13074
4 October 2013

**SECTION 75W MODIFICATION APPLICATION TO MP 09_0007 - RESPONSE TO ISSUES
STAGE 1 MOORE THEOLOGICAL COLLEGE RESOURCE AND RESEARCH BUILDING**

APPENDIX 3
TREE LOCATION PLAN SHOWING
PROPOSED DEVELOPMENT
 Moore College

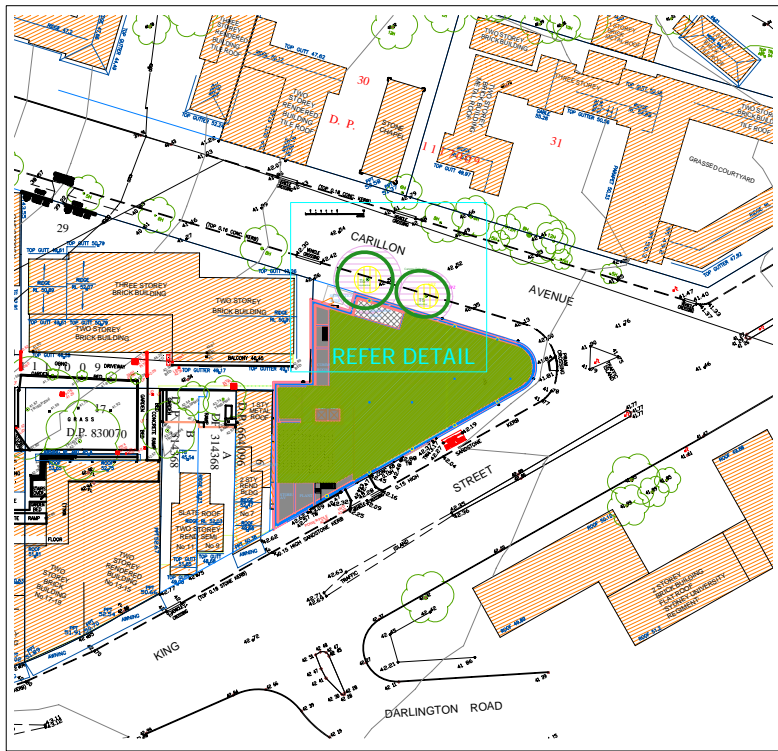
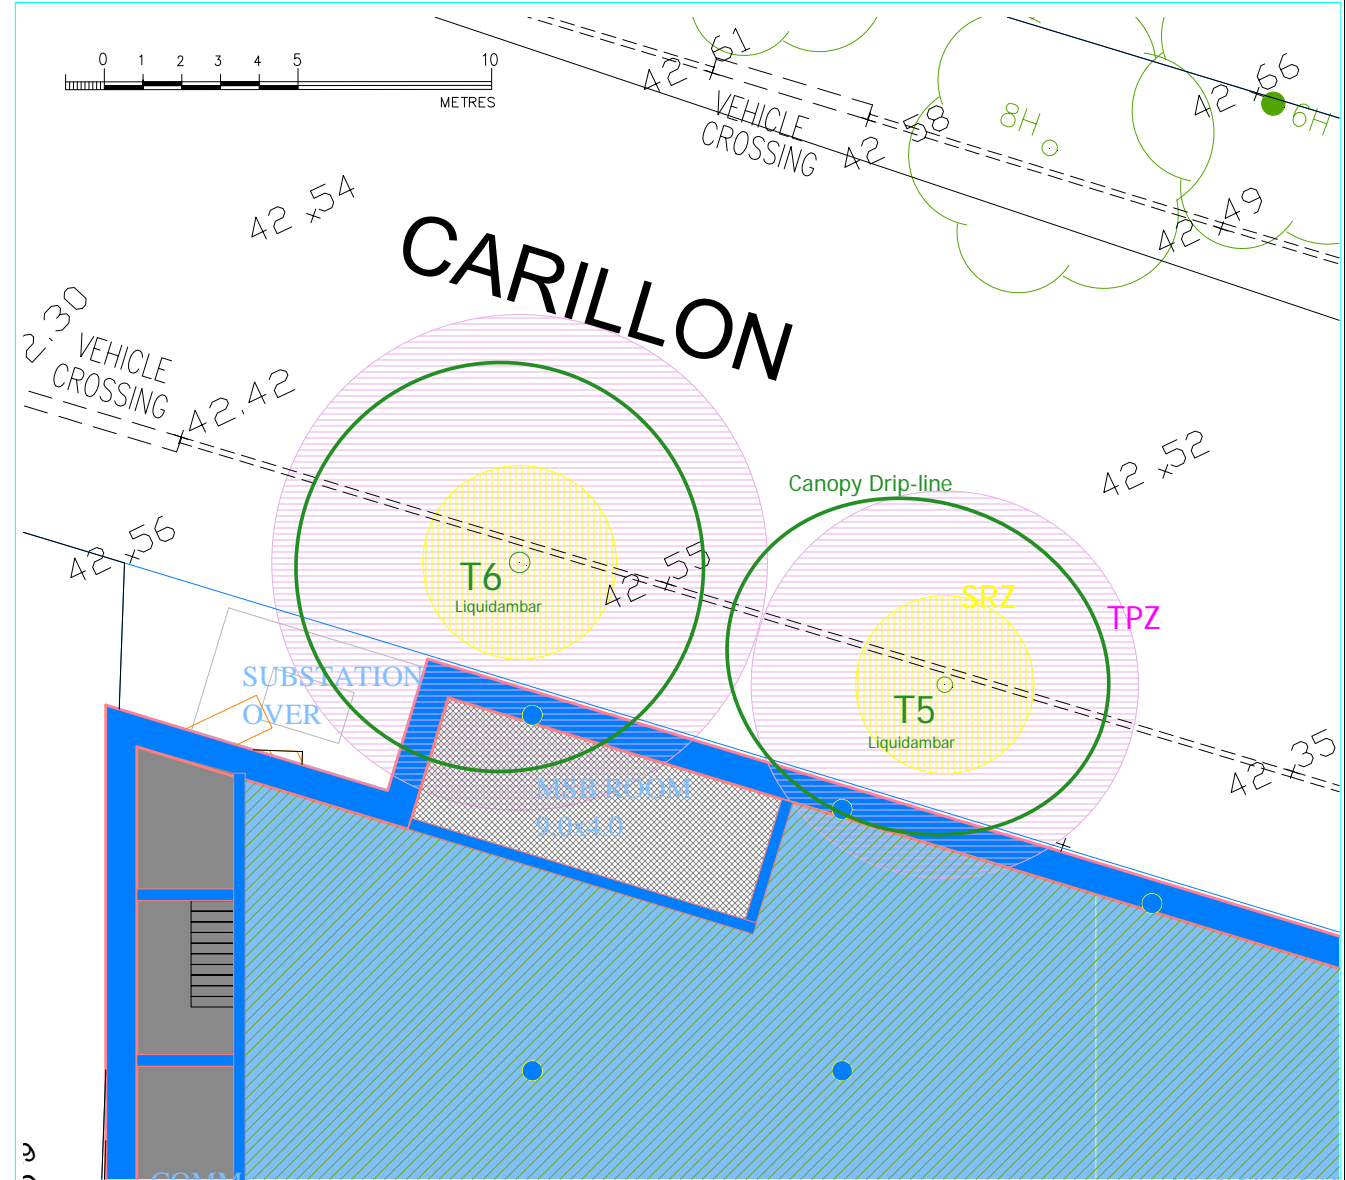
As outlined in that report, the impact on Trees T5 and T6 related to the proposed excavation for the approved basement and substation construction works encroaching into the Tree Protection Zones (TRZ) and Structural Root Zones (SRZ) of T5 and T6, and is not limited to scaffolding as suggested in Council's submission. The extent of encroachment is appended to the arborist report and is reproduced below.

Whilst Moore Theological College is willing to prune the foliage of the trees as suggested by Council, the potential impacts to the SRZ will not be alleviated through pruning. The College has taken on board the qualified arborist's recommendations that the probability of the trees sustaining the construction works is low, and accordingly sought removal of the trees in question rather than persist with their retention and risk the trees perishing. Modification of the approved building and basement to accommodate the trees is not possible, particularly as the basement has been designed fit for purpose, and optimised to accommodate the approved library space. On this basis, removal of the trees continues to be sought and is considered appropriate in the circumstances.

Drawing Title
ROOF PLAN
Drawing Status
PROJECT APPLICATION

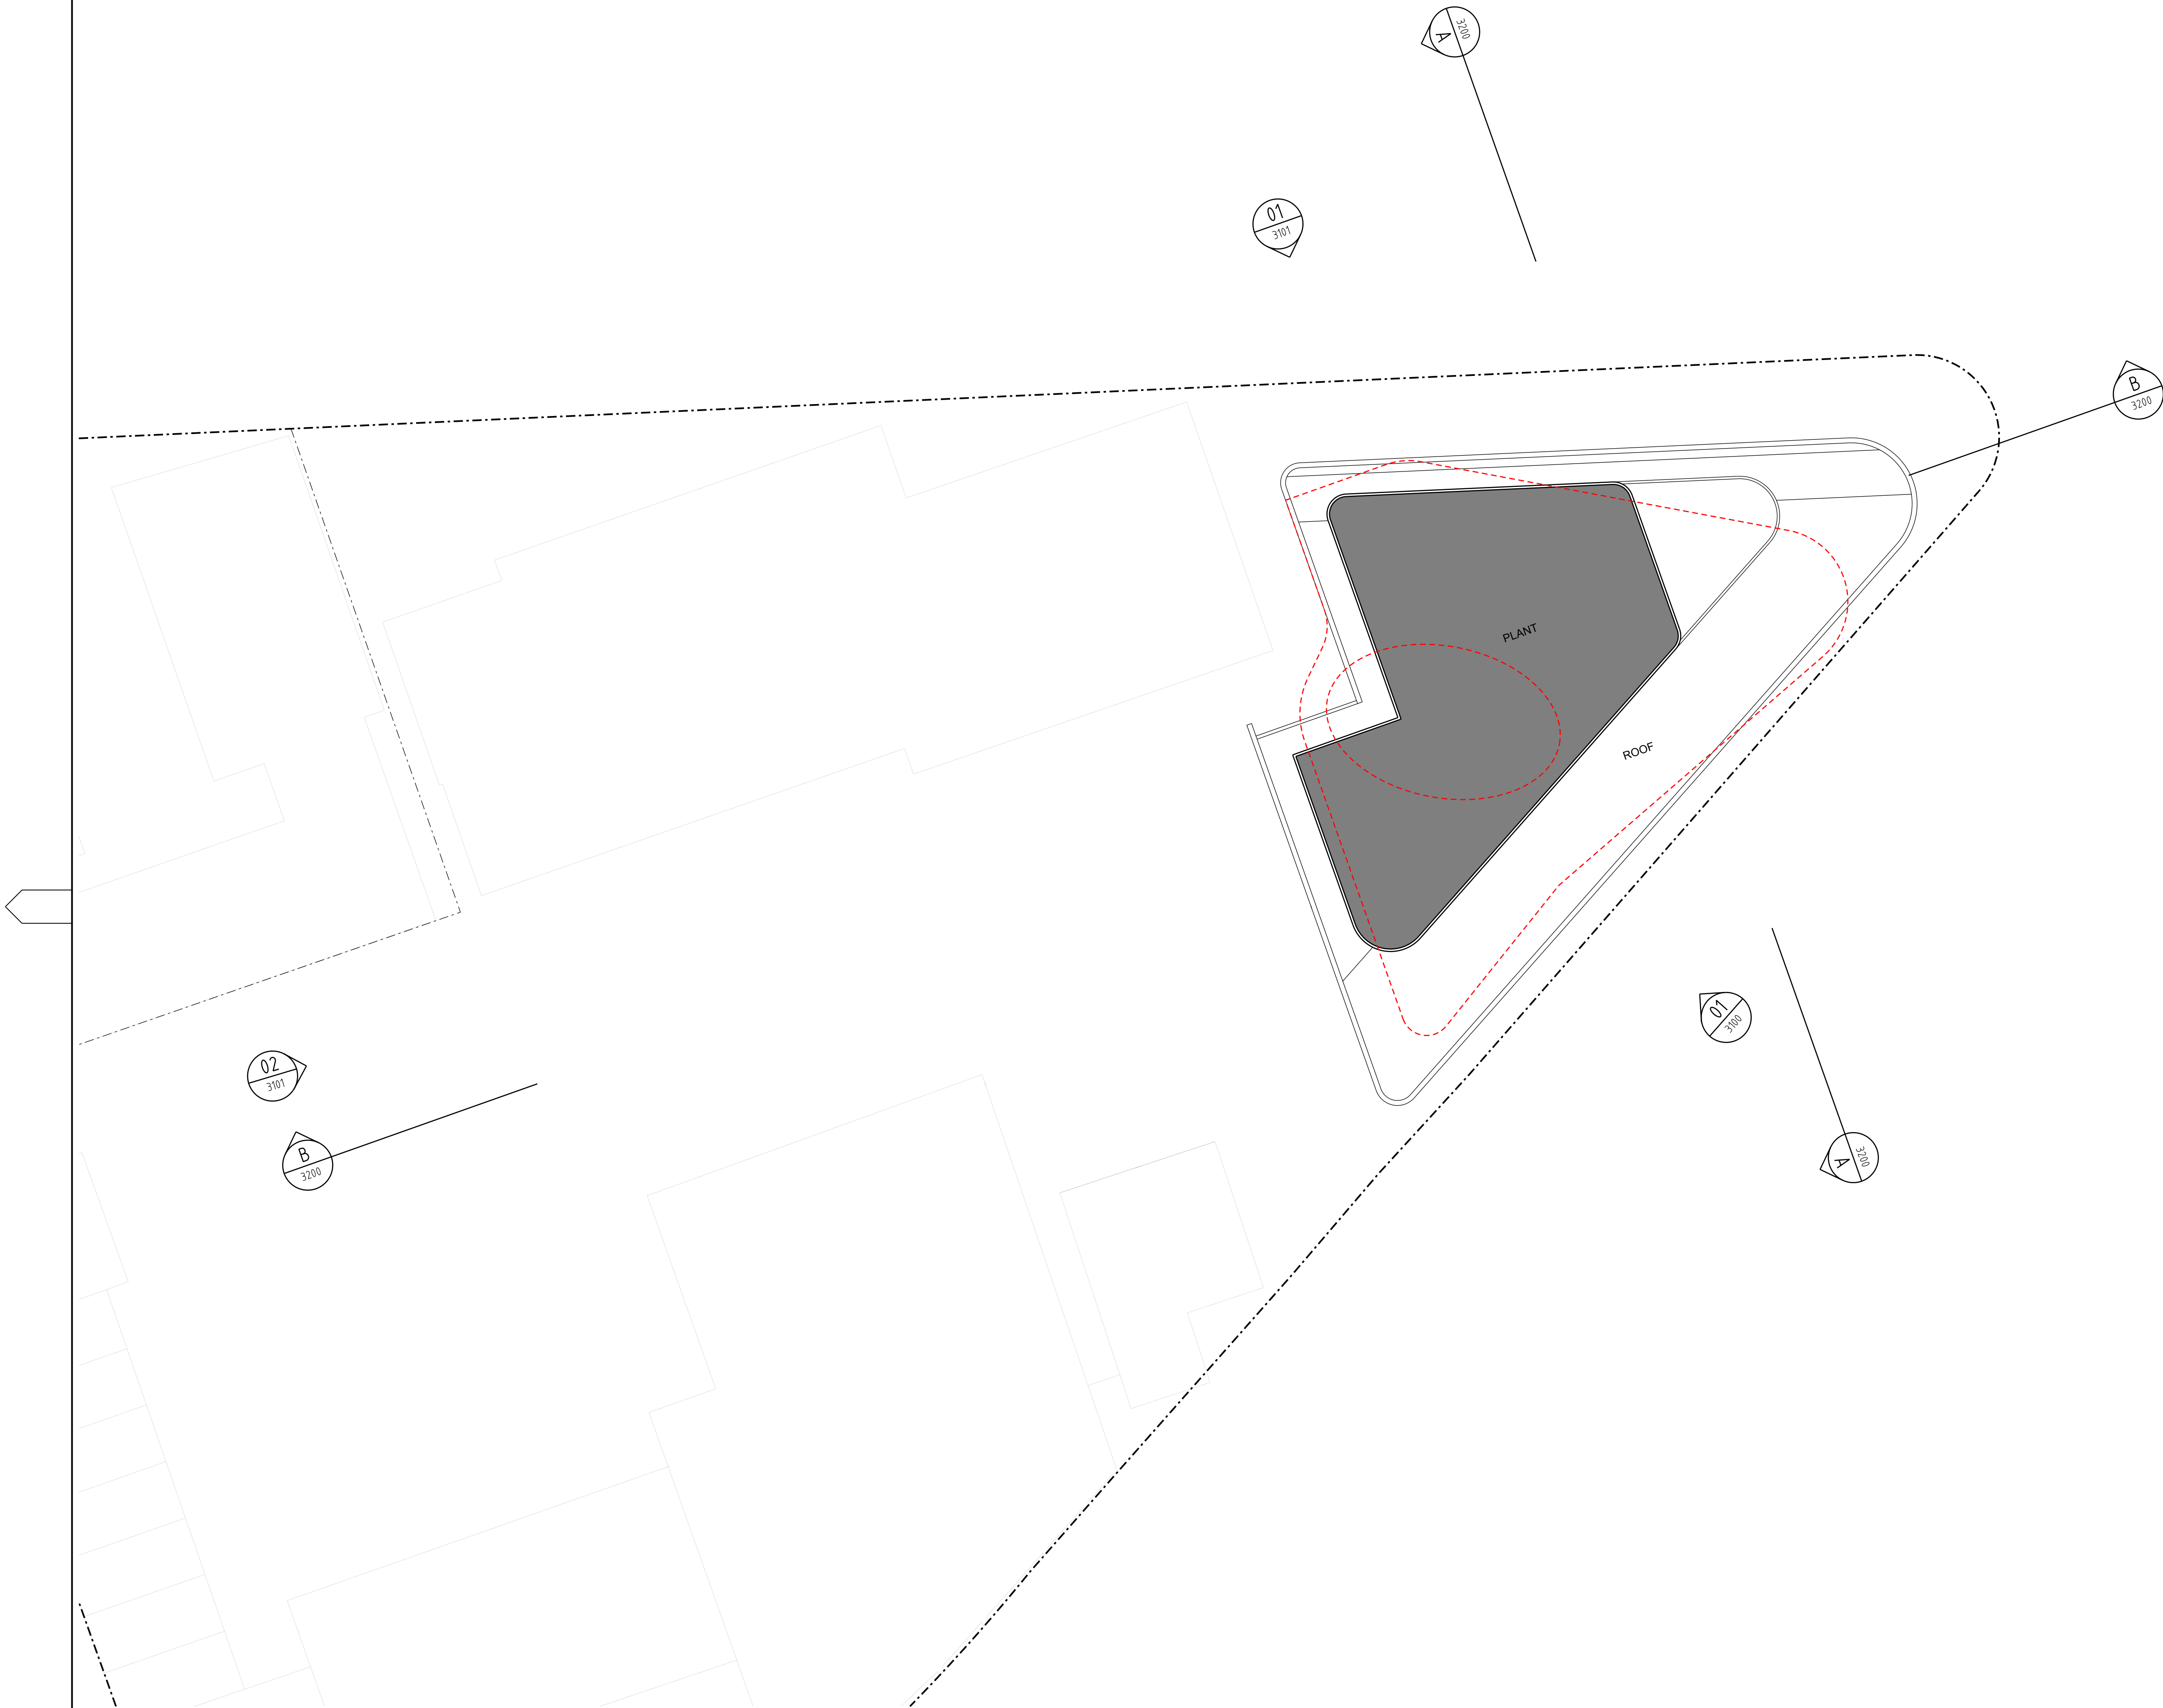
Moore Theological College understands Council's comments that the proposed plant will increase the bulk, scale and prominence of the building. However, Moore Theological College disagrees with Council's comments that the plant be reduced, as it has been designed specifically to meet the servicing needs of the development, whilst also achieving important project cost objectives which must be met if the development is to proceed. As outlined in the modification application, the proposed plant continues to comply with the approved Concept Plan's maximum permissible of height of 6 storeys and RL 70.6m. The plant is not wholly visible from all public areas and in fact will read as part of the building when viewed from City Road, and the shadowing impacts arising from the plant's location on the roof are no greater than those already deemed acceptable as part of the Stage 1 Project Application approval, and in some cases the modified design provides a reduced shadow footprint. Further, the plant has been suitably setback from the edges of the lower storey and a recessive colour choice has been made to further reduce the appearance of the plant.

The plant area has been predominantly located towards the southern edge of the building away from the Carillon and City Street frontages without providing any additional overshadowing to that previously approved.
